Re: Consultation for proposed hospital redevelopment at 177 Grose Vale Road, North Richmond (SSD-10394)

This letter has been prepared on behalf of St John of God Health Care (the proponent) to seek the views of relevant agencies in relation to a State Significant Development Application (SSD application) (SSD-10394) for redevelopment of a psychiatric hospital at 177 Grose Vale Road, North Richmond.

**Public Authority Consultation –
State Significant Development (SSD) 10394 St John of God Health Care**

01 NORTH ELEVATION  
SCALE: 1:200

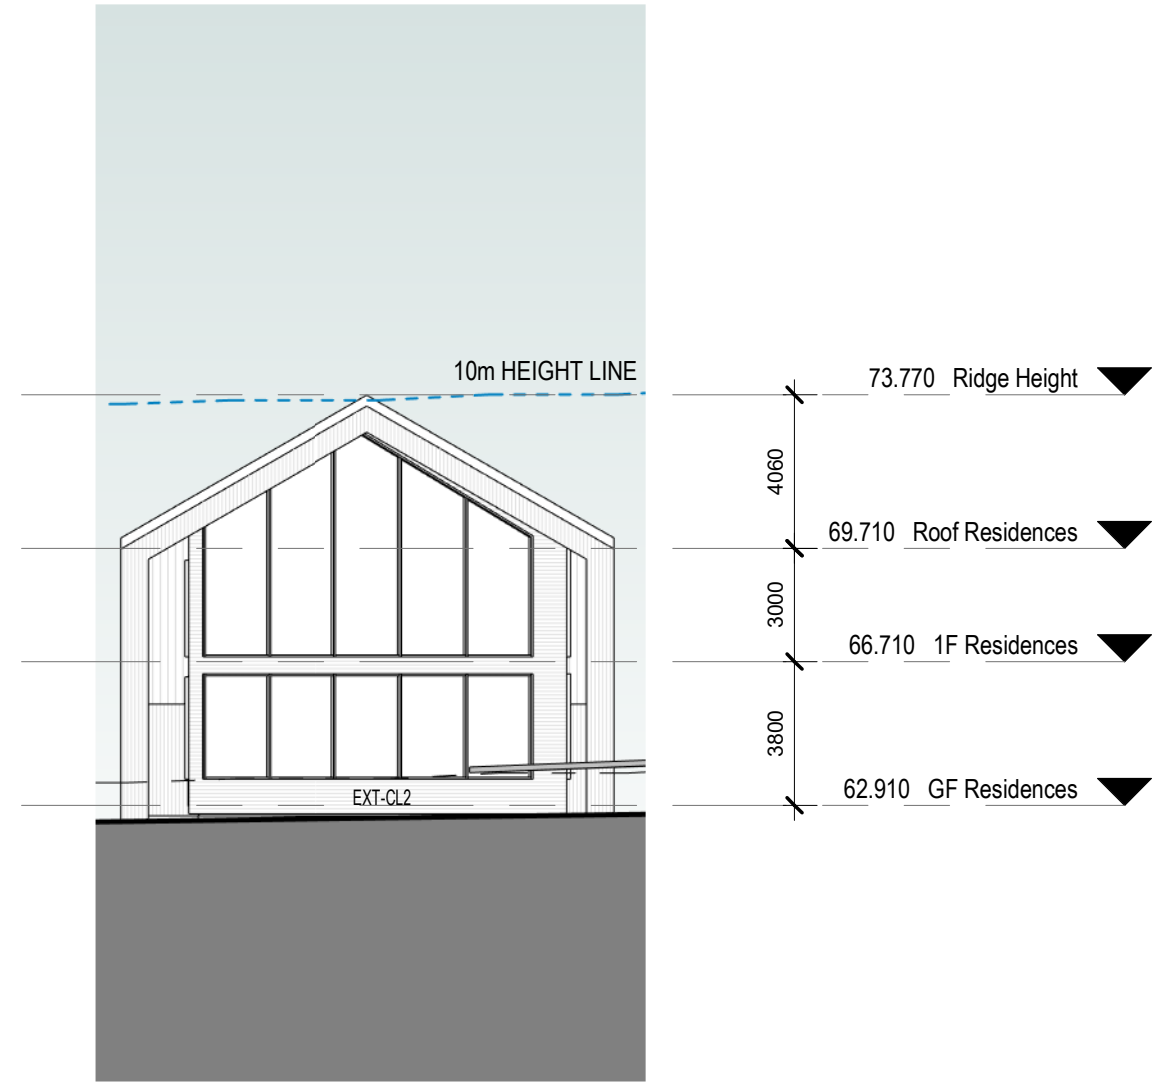
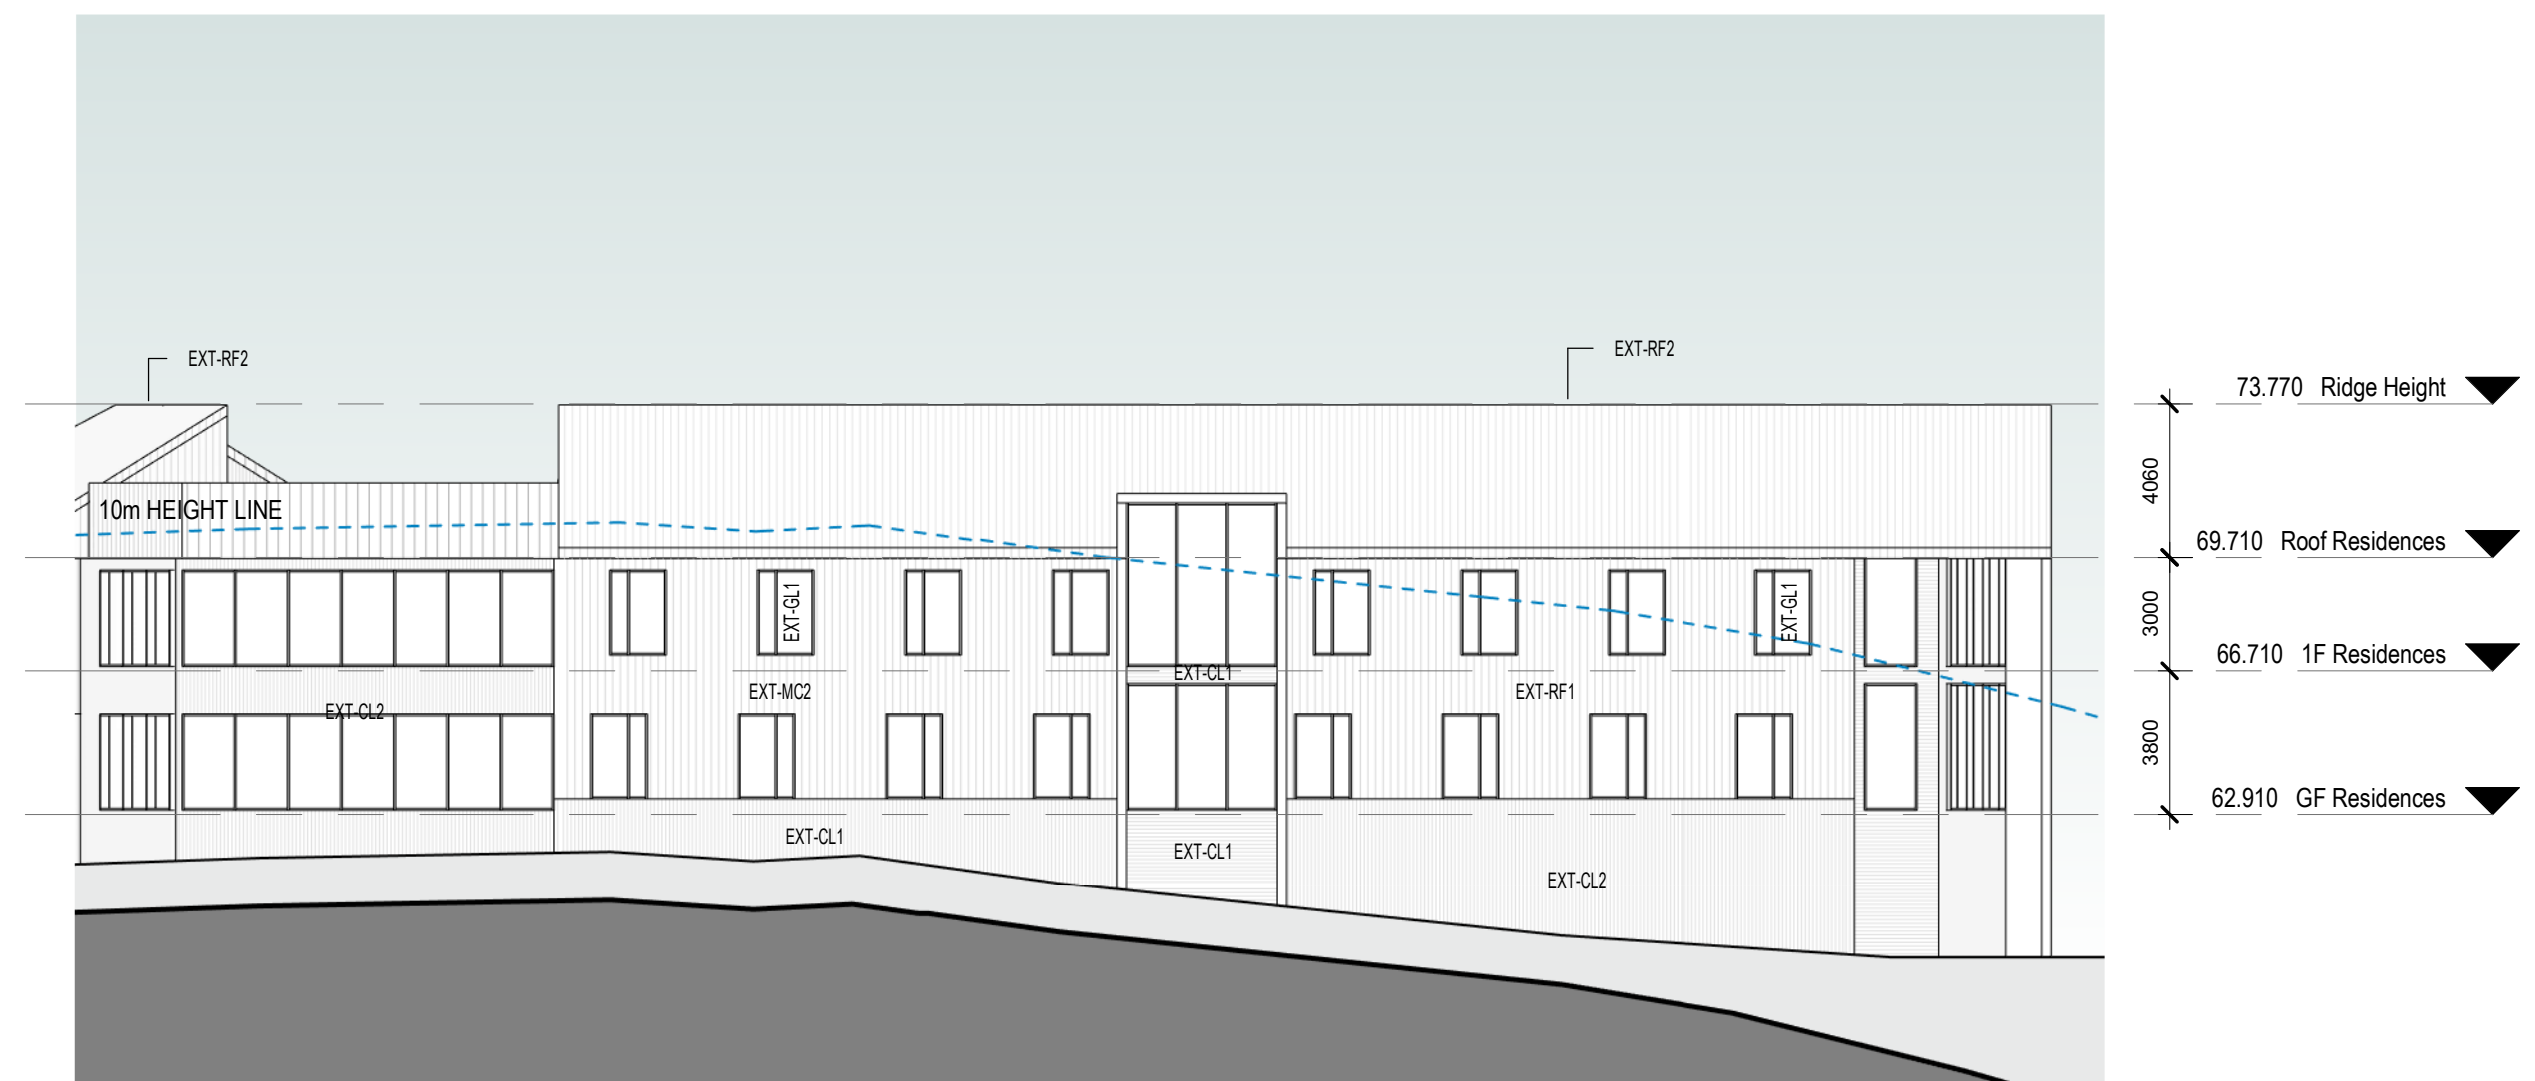
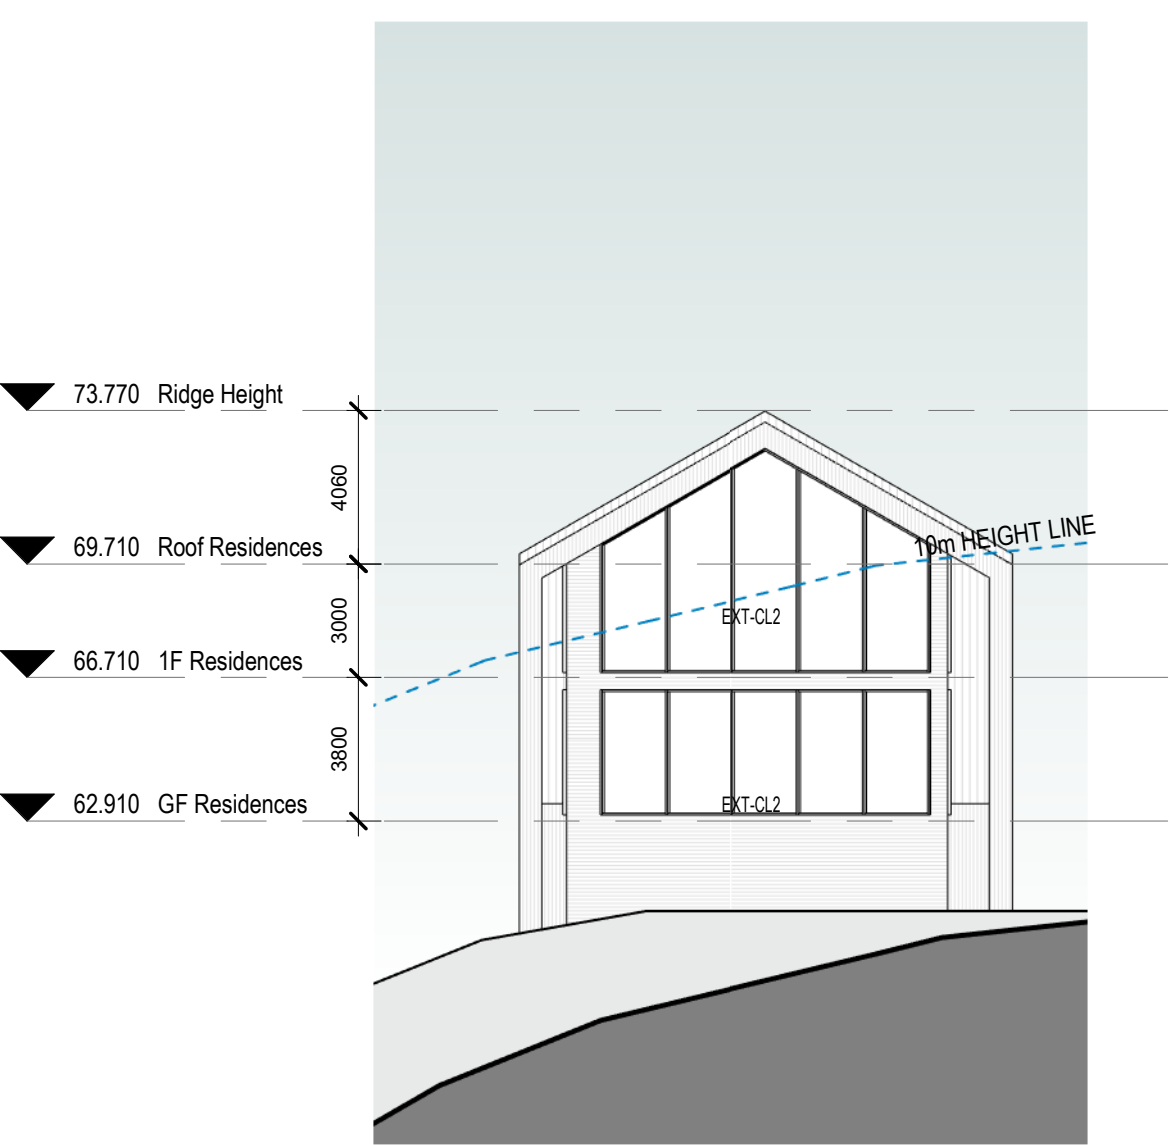
Thanks for the letter and the added detail. We have no objections to the redevelopment in principle, however need to confirm the heights of the ground and buildings:

- Per page 9 of the request for SEARs (<https://majorprojects.planningportal.nsw.gov.au/prweb/PRRestService/mp/01/getContent?AttachRef=PDA-1122%2120191108T051541.122%20GMT>), the site has a maximum building height of 10 metres marked 'K' on the Height of Buildings Map (I could not however access a map titled Height of building Map when looking through the documents).

- Request confirmation of the highest building height in meters RL. I note the RL of 62.50m for the ground floor (and 66.50m for the first floor) in the architectural plans <https://majorprojects.planningportal.nsw.gov.au/prweb/PRRestService/mp/01/getContent?AttachRef=PDA-1122%2120191024T034143.878%20GMT>, so the top of the highest building should be no more than 72.50m RL unless I'm misinterpreting the documents. Please confirm that the top of the highest building is no more than 72.50 RL, and of not please advise what it is.

The highest RL of the new build will be **RL 73.77**. See below snapshot from the architect.
